## **Planning Act 2008 (as amended) – Section 51**

### **Application by RWE Renewables UK Dogger Bank South (West) Limited and RWE Renewables UK Dogger Bank South (East) Limited for an Order Granting Development Consent for the Dogger Bank South Offshore Wind Farms**

#### **Advice following issue of decision to accept the application for examination**

DRAWING TITLE
Offshore Statutory and Non-Statutory Nature Conservation Sites

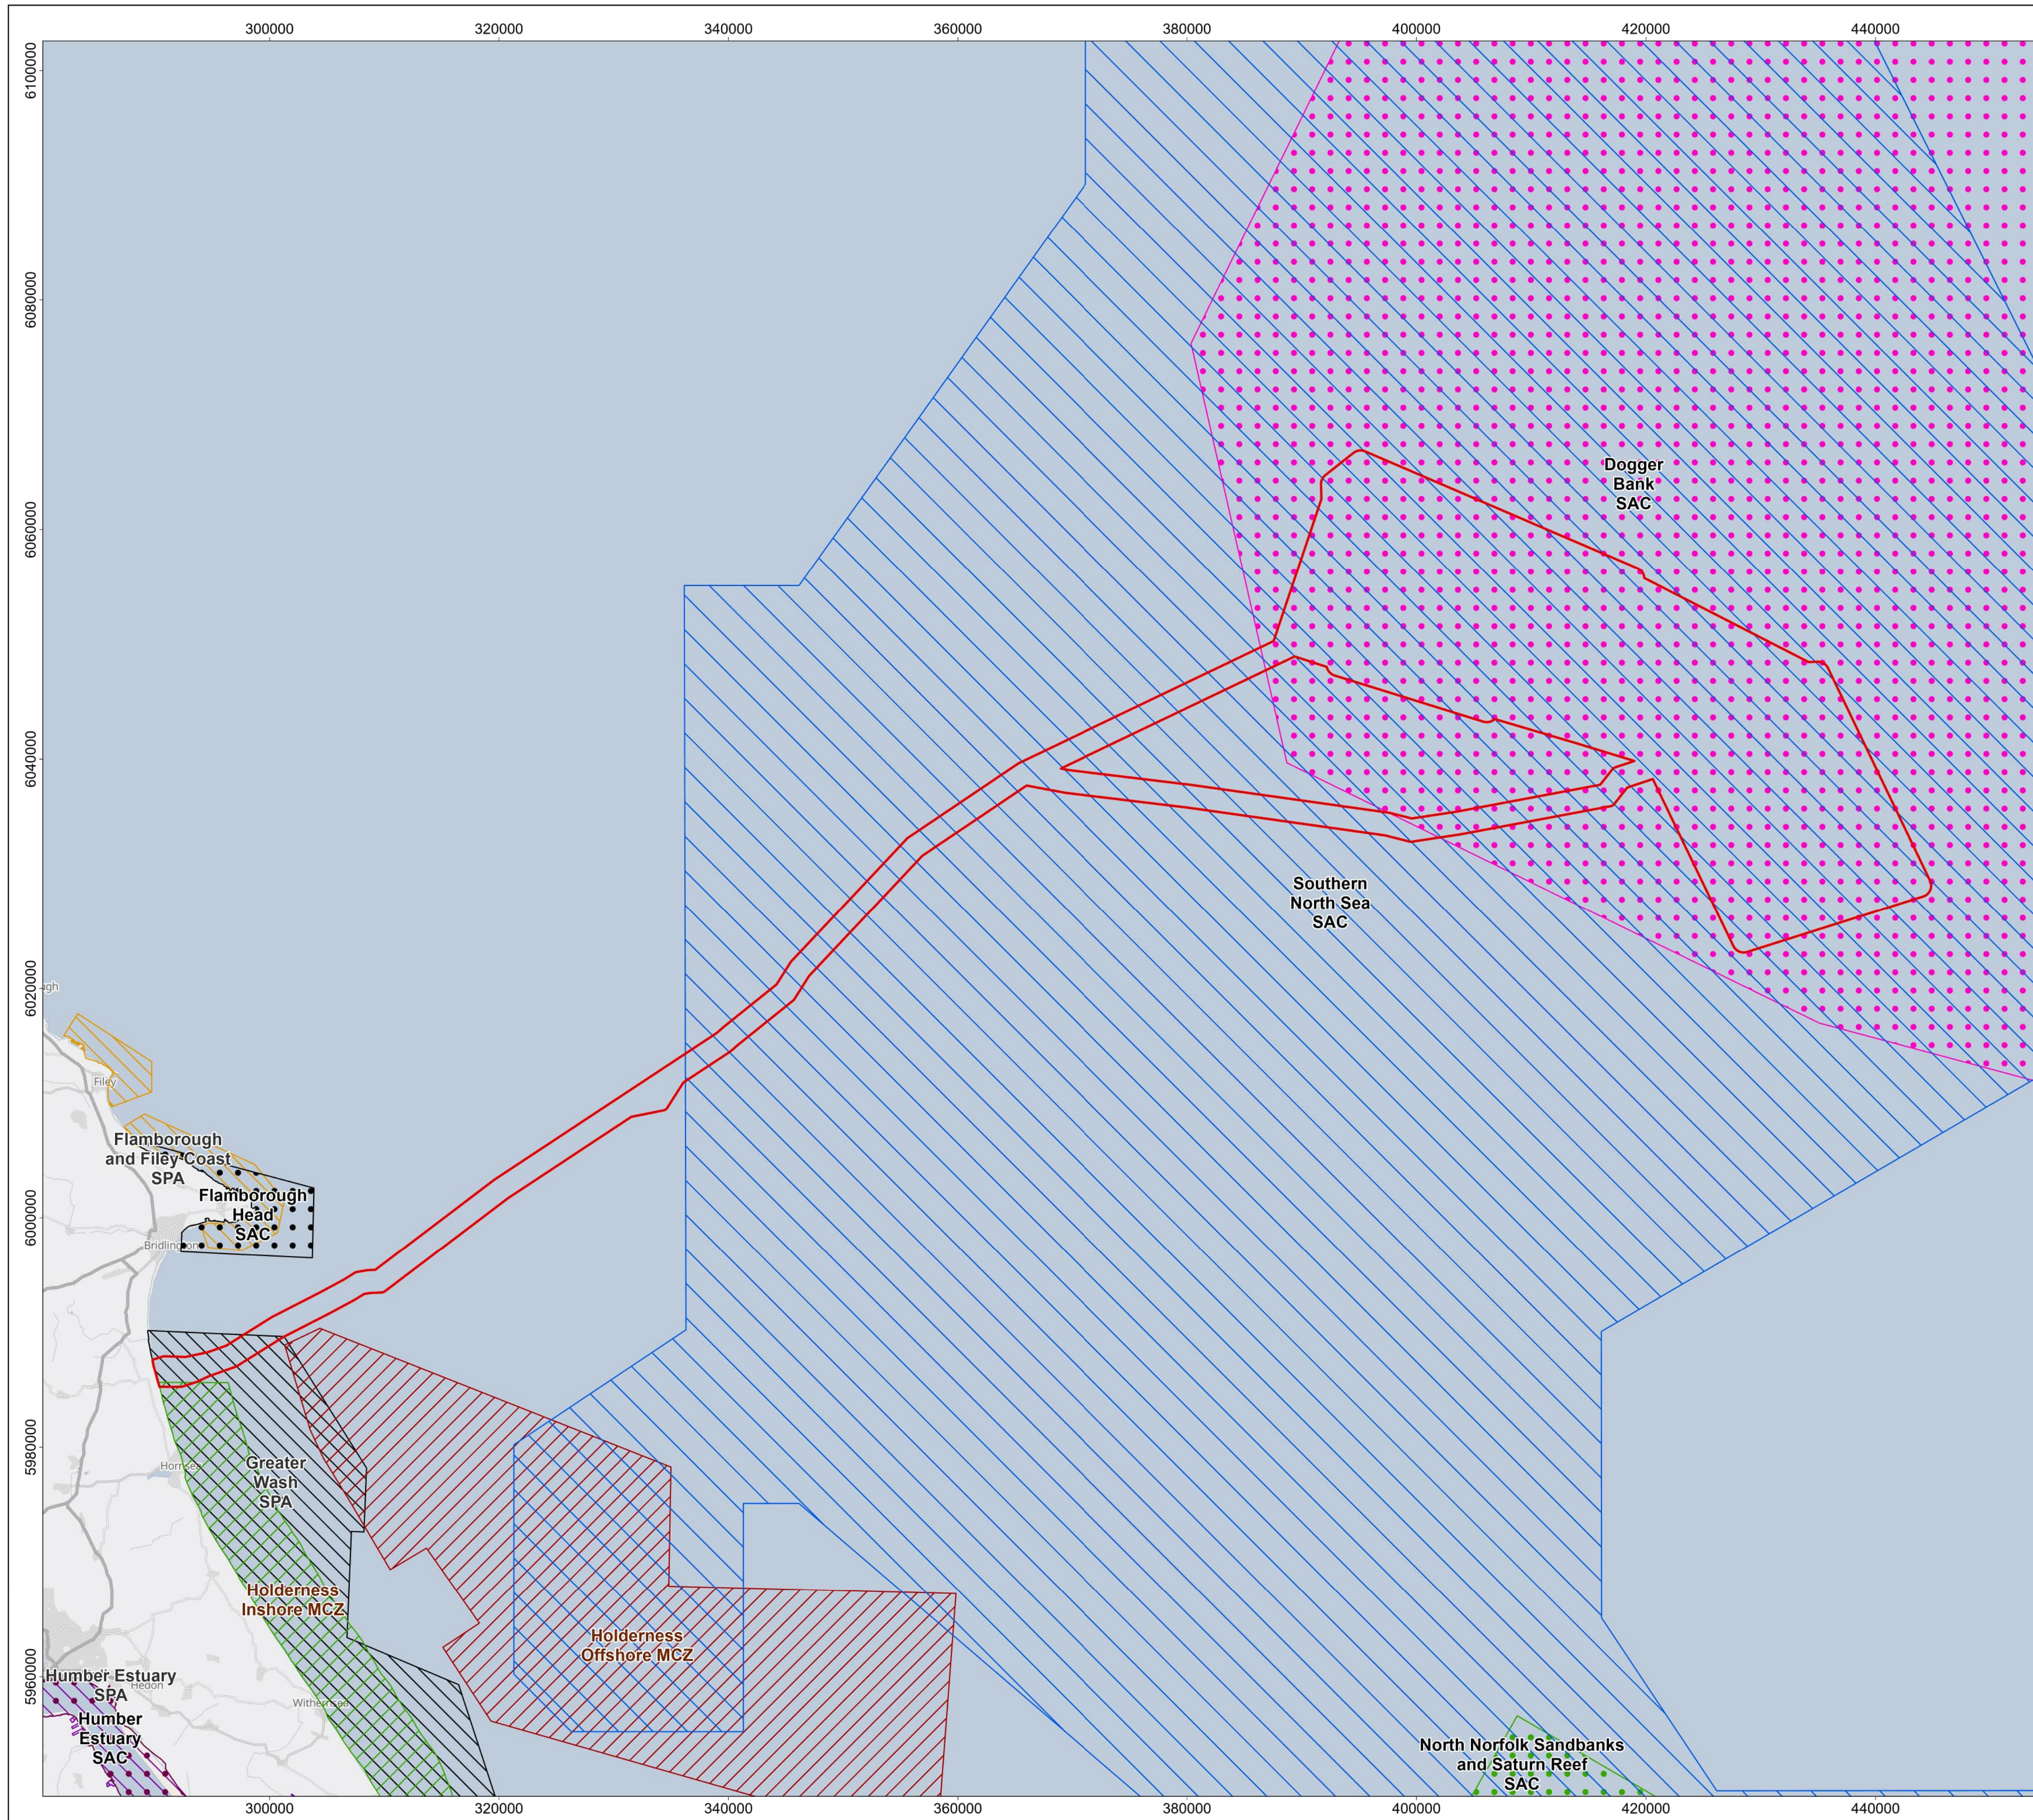
The **Offshore Statutory and Non-Statutory Nature Conservation Sites Plan (Doc 2.13)** identifies the relevant sites considered in **ES Chapter 12 (Offshore Ornithology) (Doc 7.12)** and **Report to Inform Appropriate Assessment (RIAA) (Doc 6.1)**, with the exception of Special Protection Areas (SPAs) beyond 10km from the Proposed Development (eg Farne Islands SPA or SPAs in Scotland). The Applicant is requested to provide plans/figures to illustrate the locations of these SPAs.
